# SSD 16\_7539: DARLINGTON TERRACES MIXED USE DEVELOPMENT

## THE UNIVERSITY OF SYDNEY, DARLINGTON CAMPUS

### AMENDMENT TO THE PROPOSAL

### RESPONSE TO SUBMISSIONS

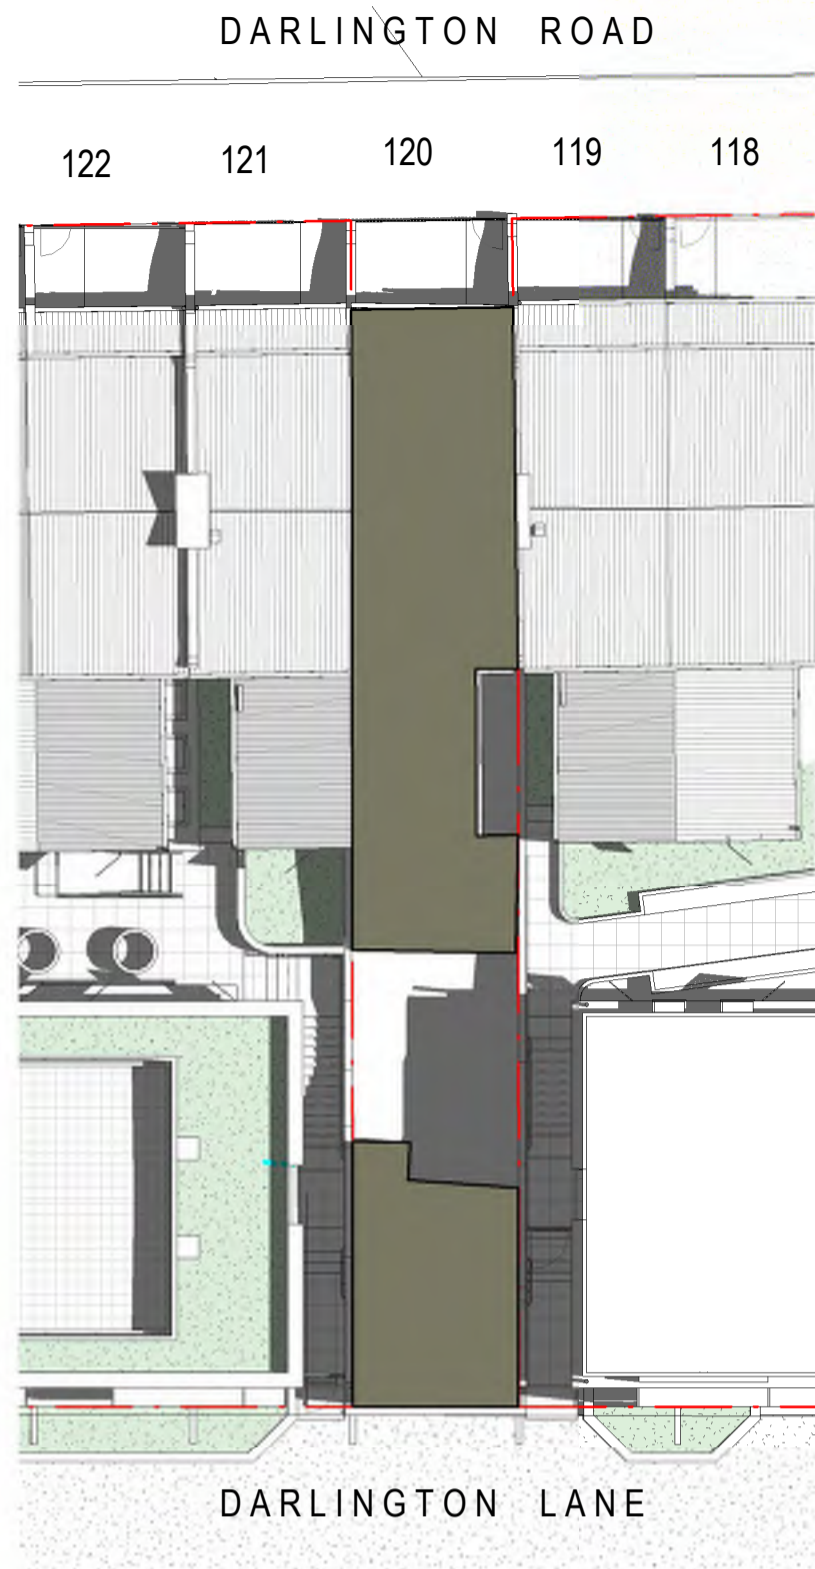
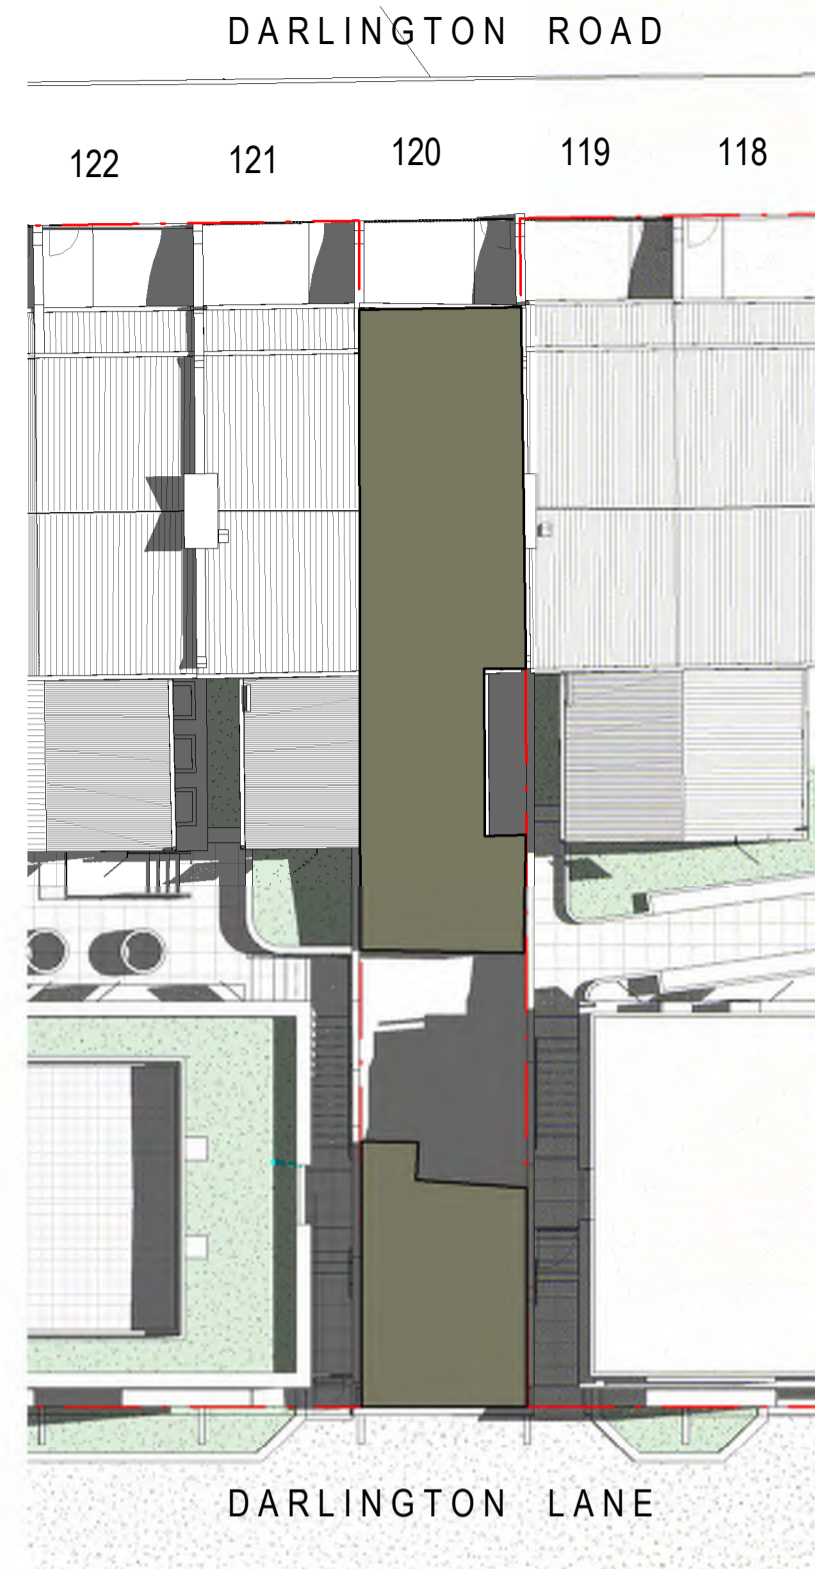
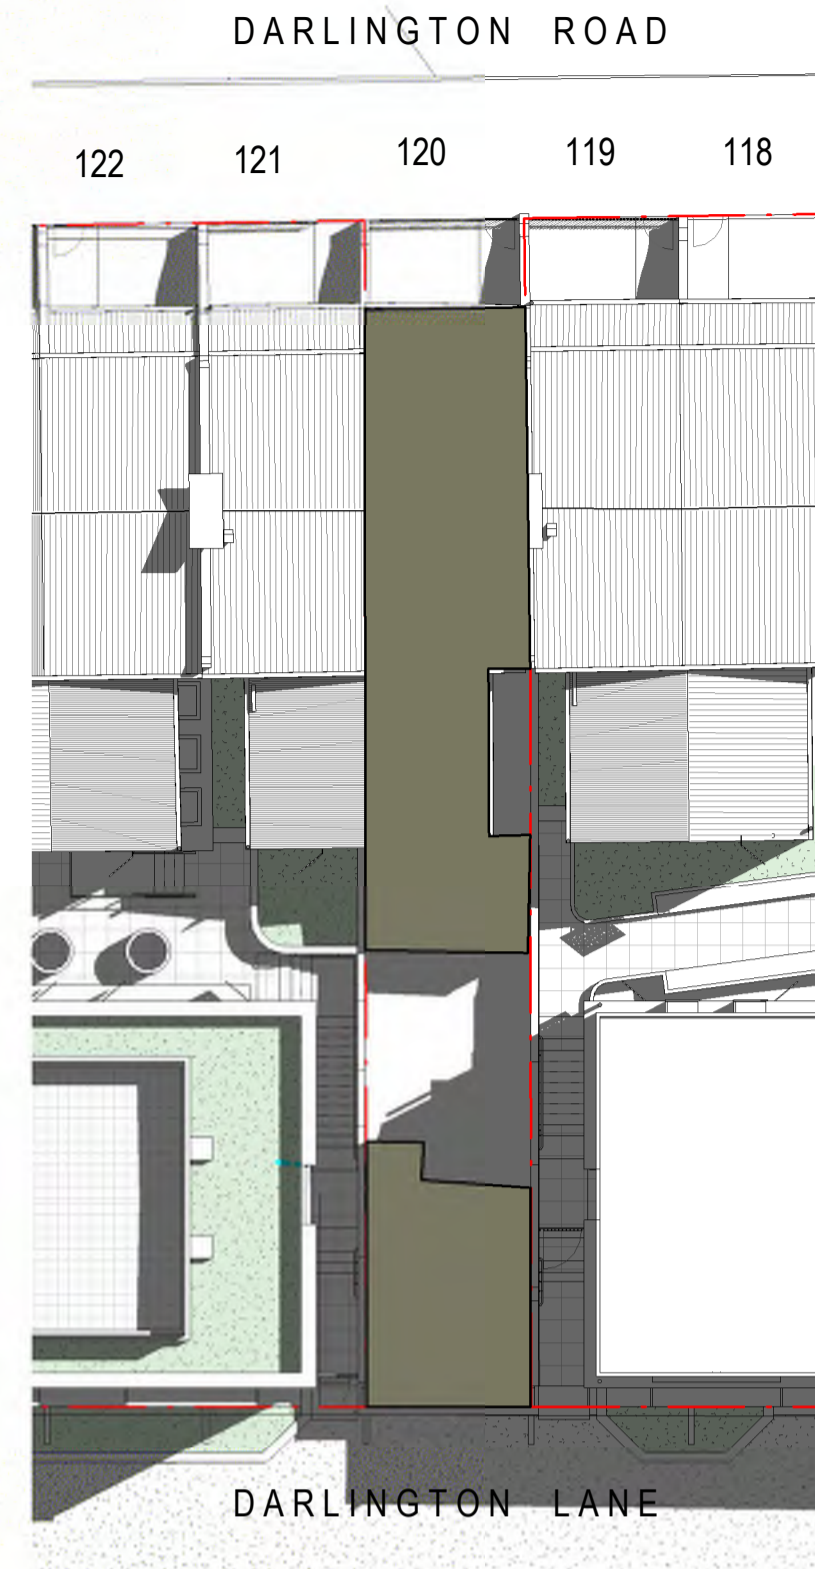
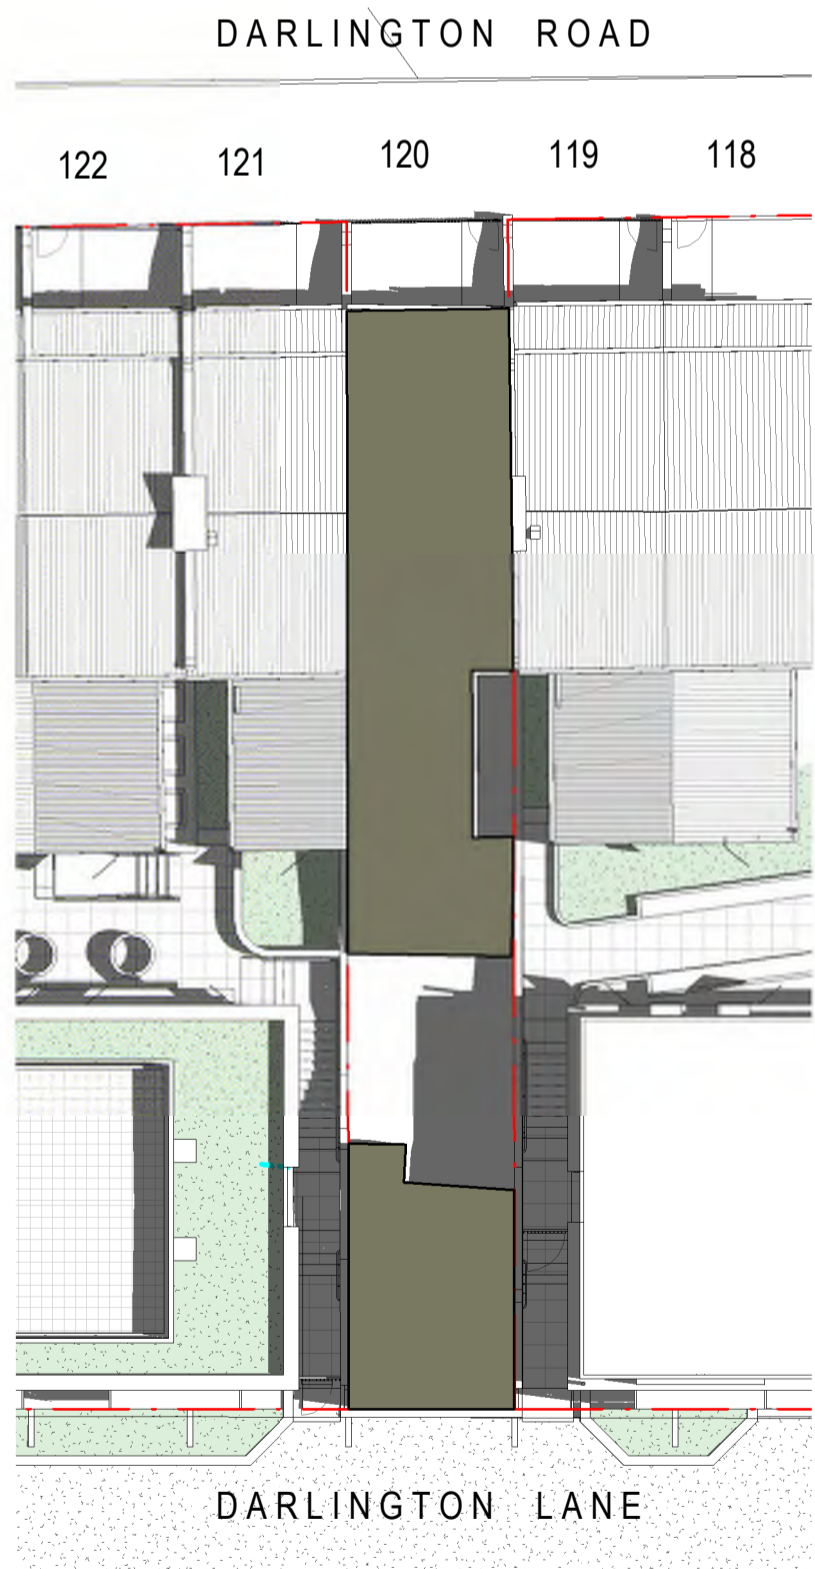
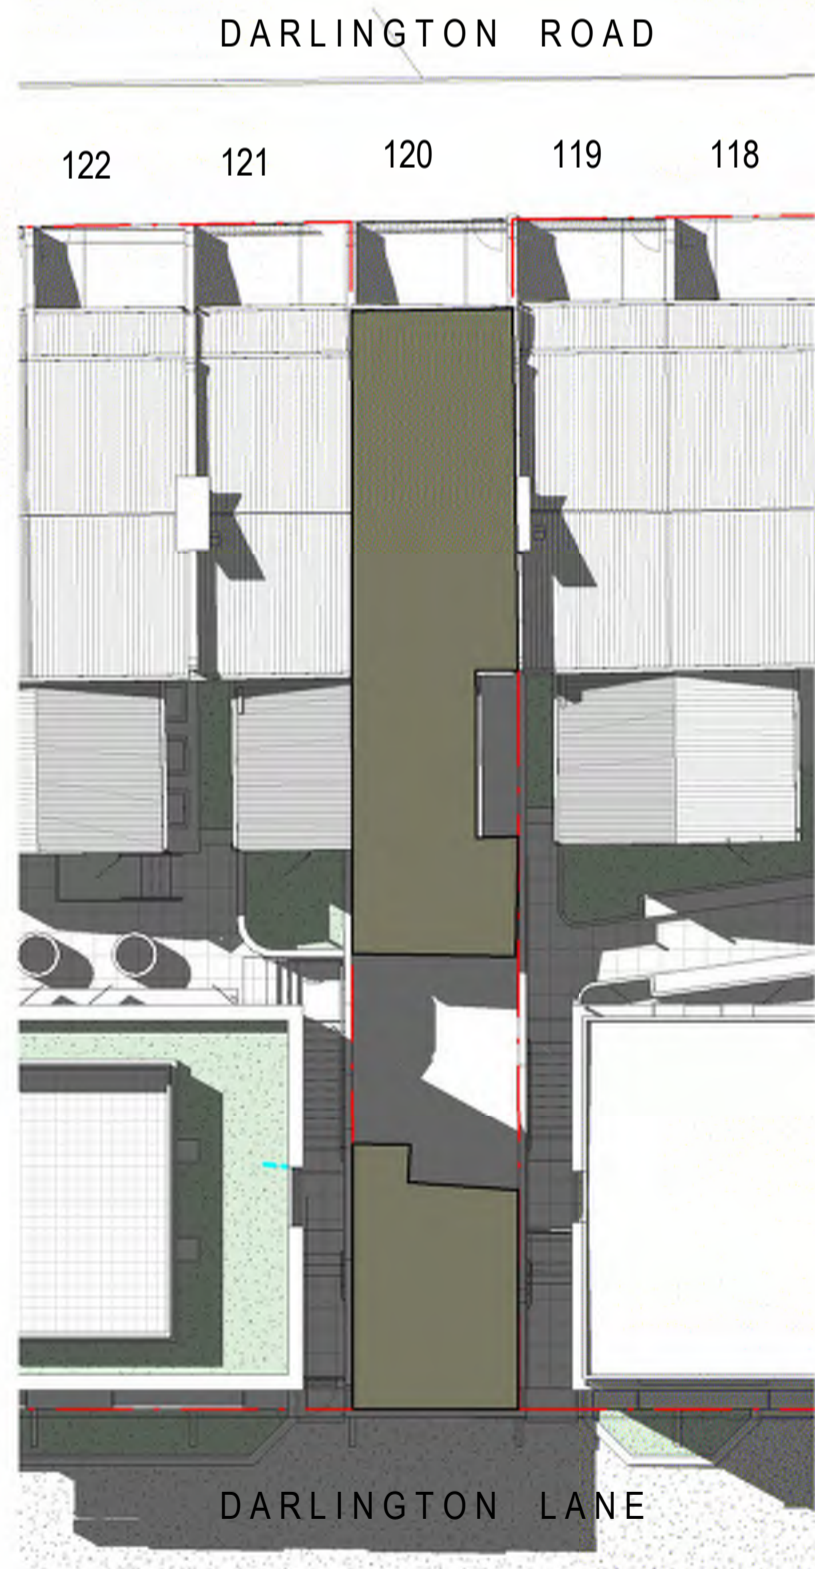
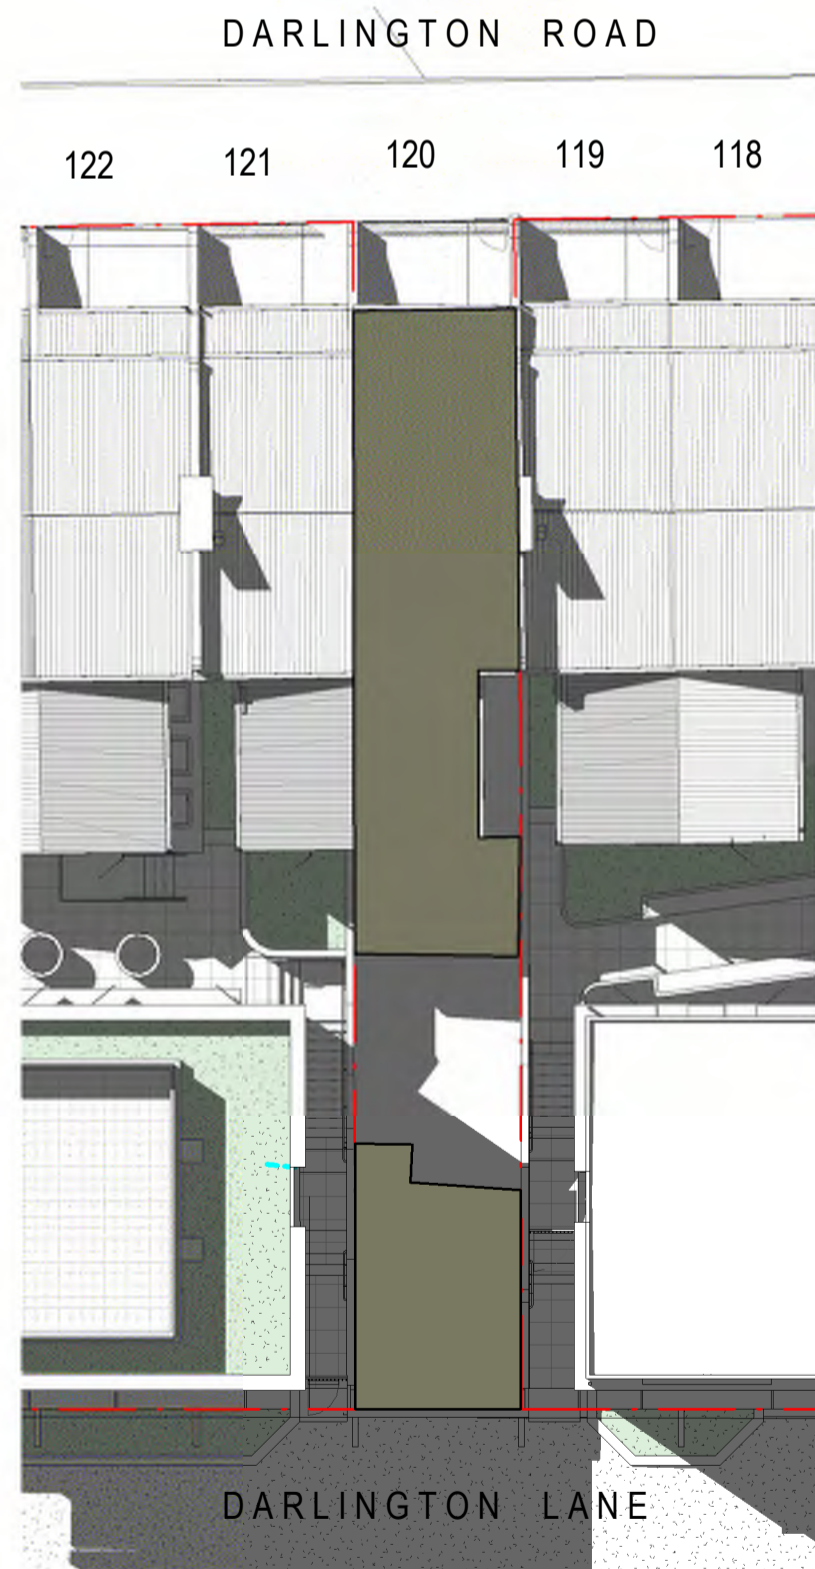
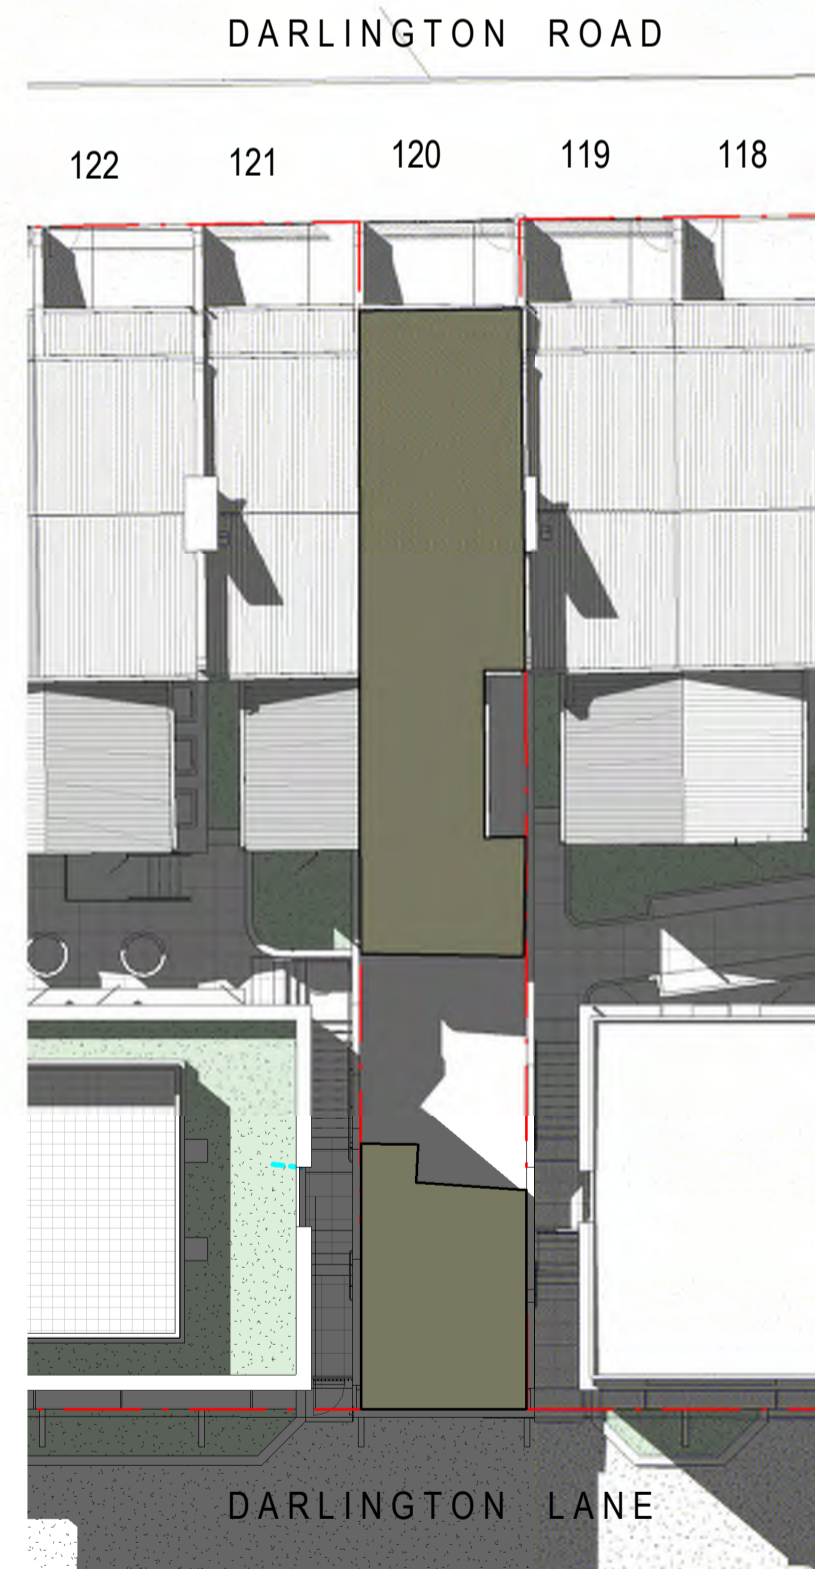
<p><b>Residential Amenity</b></p> <p>3. The overshadowing analysis must illustrate that adequate solar access has been maintained to the adjoining private residential properties and additional overshadowing from the proposal does not result affected properties retaining less than a minimum two hours of solar access to 50 per cent of the private open space areas between 9 am and 3 pm on 21 June. Additional shadow diagrams illustrating overshadowing at hourly intervals (at a minimum) must be provided to clearly demonstrate impacts on open space areas of the private residential properties affected by the proposal.</p>	<p><b>Agreed:</b> The amended Shadow Analysis by project architects AJ+C are addressed in the package of Architectural Plans (<b>Appendix A-3</b>). The two privately owned Terraces located in between the proposed new buildings are No’s 120 and 97 Darlington Road and the Shadow impacts to the rear yards of these Terraces are addressed at <b>Appendix A-4</b>.</p> <p>The AJ+C Shadow Analysis confirms that:</p> <ul style="list-style-type: none"> <li>• No. 120 Darlington Road currently receives less than 2 hours sunlight to 50% of open space, and will not receive any additional shadows to the rear yard of the property because of the proposed development; and</li> <li>• No. 97 Darlington Road currently receives less than 2 hours sunlight to 50% of open space. The design of new Building Block D, immediately to the east of and adjoining 97 Darlington Road, has been modified by including a splayed treatment at its north-western corner, in order to avoid any additional overshadowing and thereby ensure that current levels of solar access to the rear yard of (private) 97 Darlington Street are maintained as existing.</li> </ul>

SSD 16_7539 – DARLINGTON TERRACES MIXED USE DEVELOPMENT	
DPIE KEY ISSUE	UNIVERSITY PROJECT RESPONSE
	<p>The AJ+C shadow analysis at <b>Appendix A</b> also includes an hour-by-hour birds eye view of solar access which demonstrates that compliant levels of solar access will be provided to the north facing elevations of the new Darlington Terraces. Solar access to the street front facades of the original Darlington Terraces fronting Darlington Road will remain unaltered.</p>
<p>4. Further <b>Shadow Impacts</b> upon (private) 120 Darlington Road:</p> <ul style="list-style-type: none"> <li>• DPIE acknowledges no mid-winter shadow impacts or any solar reception.</li> <li>• DPIE request an assessment of solar impacts at other times of the year to ascertain what solar access 120 Darlington will receive for min 8sq.m. for period of 2 hours.</li> <li>• If the above-mentioned solar access cannot be received, then USYD to consider built form amendment.</li> <li>• Seek commentary on built form compliance with CIP for solar access.</li> </ul>	<p><b>Agreed:</b> Additional Solar Access Plans (Dwgs DA3910 - DA3913) have been prepared by AJ+C and are found at <b>Appendix A-3</b> (overall mid-winter analysis) and <b>Appendix A-4</b> (for 120 Darlington Road).</p> <p>An analysis of the overshadowing impact of the SSD proposal to the privately owned property at 120 Darlington Road has been conducted on the 1<sup>st</sup> and 15<sup>th</sup> day of each month, and concludes:</p> <ul style="list-style-type: none"> <li>• From 01 January – 01 May (4 months) No.120 Darlington Road will receive 2 hours and above of sunlight to at least 8m<sup>2</sup> of its rear private open space (southern aspect). The property will <b>also</b> receive at least 2 hours and above sunlight to at least 8m<sup>2</sup> of its front private open space facing Darlington Road (northern aspect).</li> <li>• From 01 May – 01 September (4 months) No.120 Darlington Road will receive 2 hours and above of sunlight to at least 8m<sup>2</sup> of its front private open space facing Darlington Road (northern aspect).</li> <li>• From 01 September – 01 January (4 months) No.120 Darlington Road will receive 2 hours and above of sunlight to at least 8m<sup>2</sup> of its rear private open space (southern aspect). The property will <b>also</b> receive at least 2 hours and above of sunlight to at least 8m<sup>2</sup> of its front private open space facing Darlington Road (northern aspect).</li> </ul> <p>✓ In summary, N°.120 Darlington Road will receive at least 2 hours of sun to at least 8m<sup>2</sup> of private open space all year round and will therefore more than satisfy the objectives of <i>Sydney DCP 2012</i> clause 4.1.3.1 <i>Solar Access</i>.</p> <p>✓ Notwithstanding the solar access compliance described above, the University confirms that the built form of the rear Darlington Terraces additions complies with the maximum building envelopes approved by the CIP – SSD 13_61123 (refer to AJ+C elevations for plans to illustrate building envelope compliance at <b>Appendix A-2</b>).</p>
